SWPPP
Stormwater
Erosion Control
Reclamation
Seeding

February 26, 2026

RE: Stillbrooke Homes at La Mirada Subdivision on Wymont Circle – Erosion & Sediment Control Plan G19E004A_SB (SWQ-2026-00008)

SHEET:
3 - GENERAL NOTES

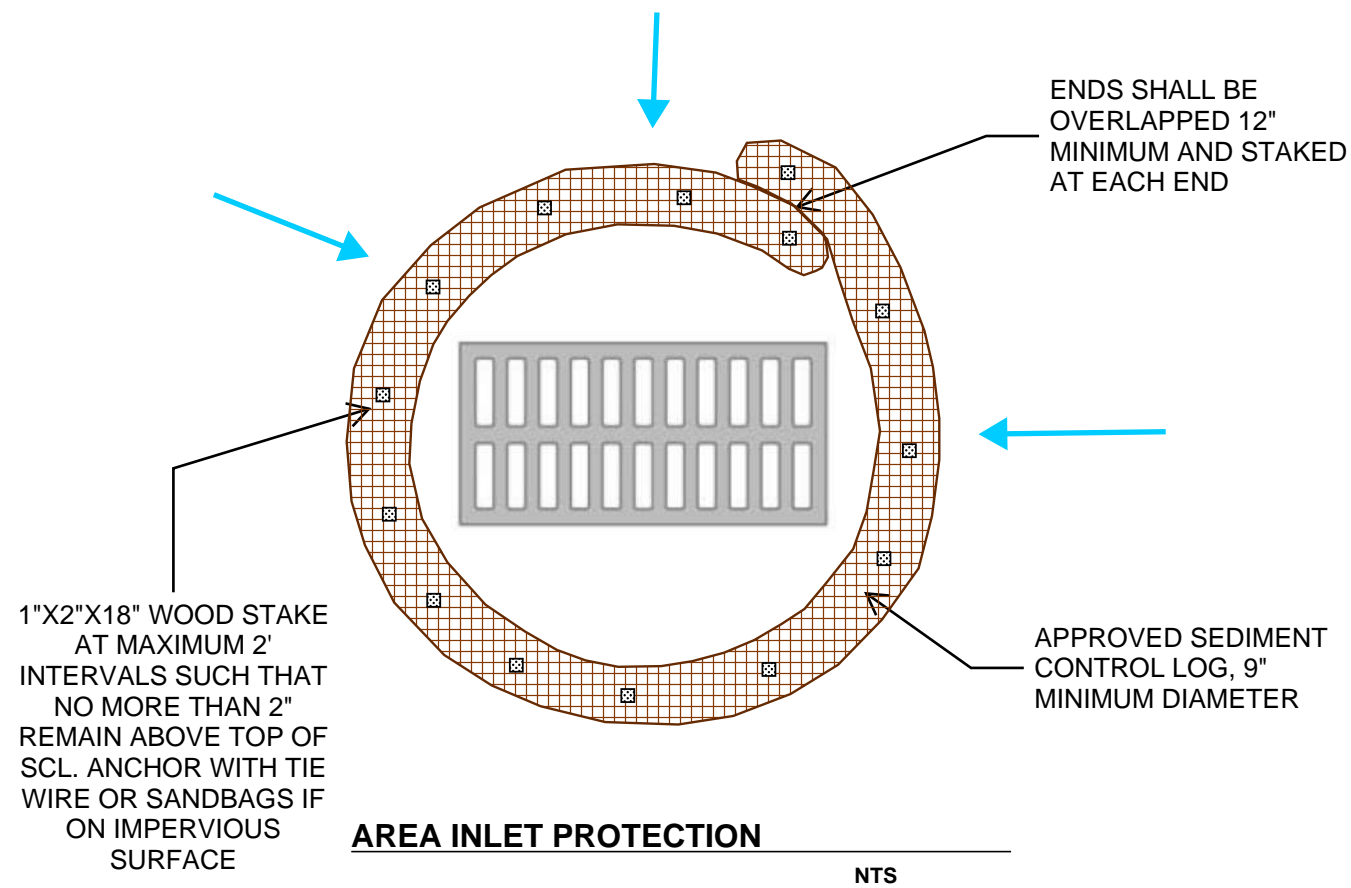
4. COA Comment 4 is difficult to parse and appears to be circular. It is not clear what the City's expectation is, or what BMP it will accept. We believe your comment is direction to install silt fence between each lot, and a cutback curb along the street. We have made this change to the TESCP.

With respect to the detention pond, this requirement is relevant for mass grading, but not for vertical construction. The SWQ department defaults to its preference to calculate a sediment basin's size based on 3,600 c.f. per acre drained. However, it omits the 'or' in Part 2.2.12 which allows the operator to design a sediment basin, if installed, around the calculated volume of runoff from a 2-year, 24-hour storm. The existing detention pond is sized to accommodate a 10-year storm.

The Operator(s) are only responsible for the permitted disturbed areas (e.g., the lots they own). They are not responsible for the entire commercial and residential subdivisions. While impractical, we can develop small sediment basins for each lot, or acknowledge the cutback curb is a pond, and contains stormwater discharge as it moves toward the street. If needed, the operator can adjust the depth of the cutback curb to accommodate more volume.

SHEET:
9

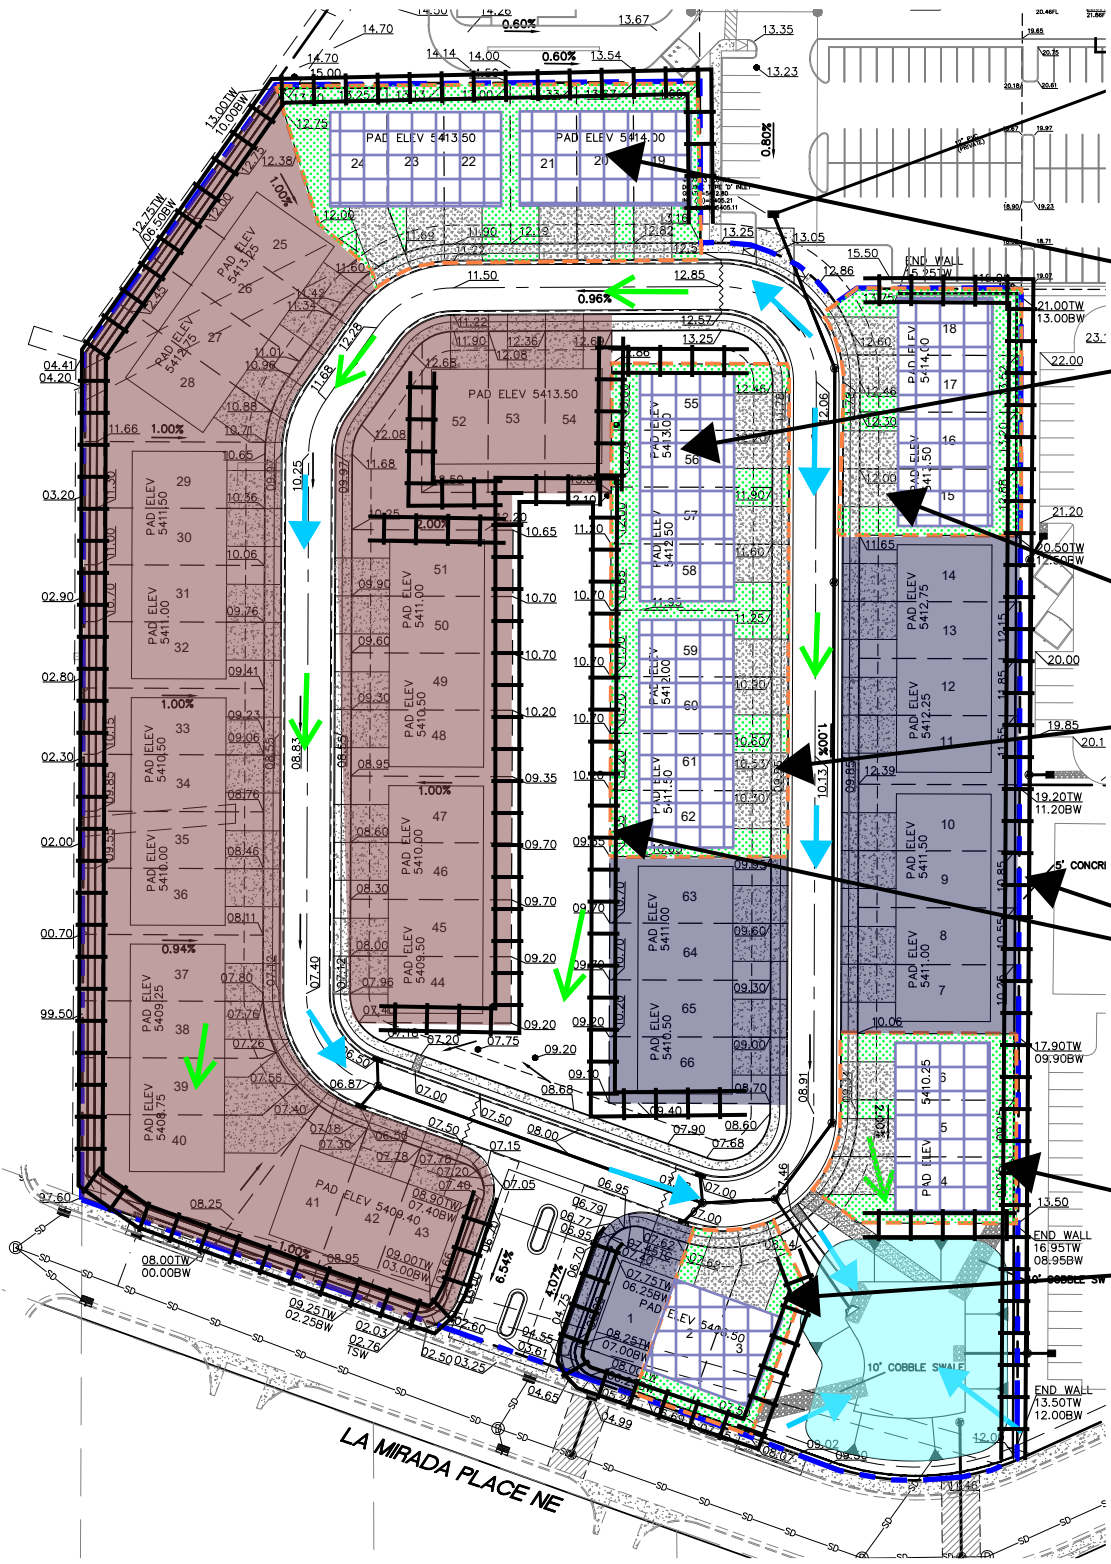
The 2022 CGP Parts 7.2.1 and 9.6.1.c.i, require the SWPPP identify all active Operators. While preparing the SWPPP, we identified active NOIs for three other Operators at the La Mirada Subdivision: AMREP Southwest, Inc. (NMR10040Z), Wymont, LLC (NMR10044X) and Twilight Homes (NMR1006BR). Additionally, the Bernalillo County Assessor identifies Amreston Homes, LLC as the current property owner for Lots 26-43 with no corresponding NOI located on the EPA's public permit search site. However, the respective NOIs for AMREP Southwest, Inc., Wymont, LLC and Twilight Homes are accessible on the EPA's public permit search site. The search results for each indicate they are still active.

During review, we identified that Wymont, LLC (NPDES ID NMR10044X) also needed to be included on the plan in addition to the ones previously identified as an active operator for the relevant lots.

We cannot claim to know the status of the work authorized under permits NMR10040Z or NMR10044X, or why they are still active if the work is complete. Similarly, the NOIs do not specify which lot/s the authorizations are for. However, to comply with CGP Part 7.2.1 and 9.6.1.c.i, we labeled the lots based on the Bernalillo County Assessor's data.
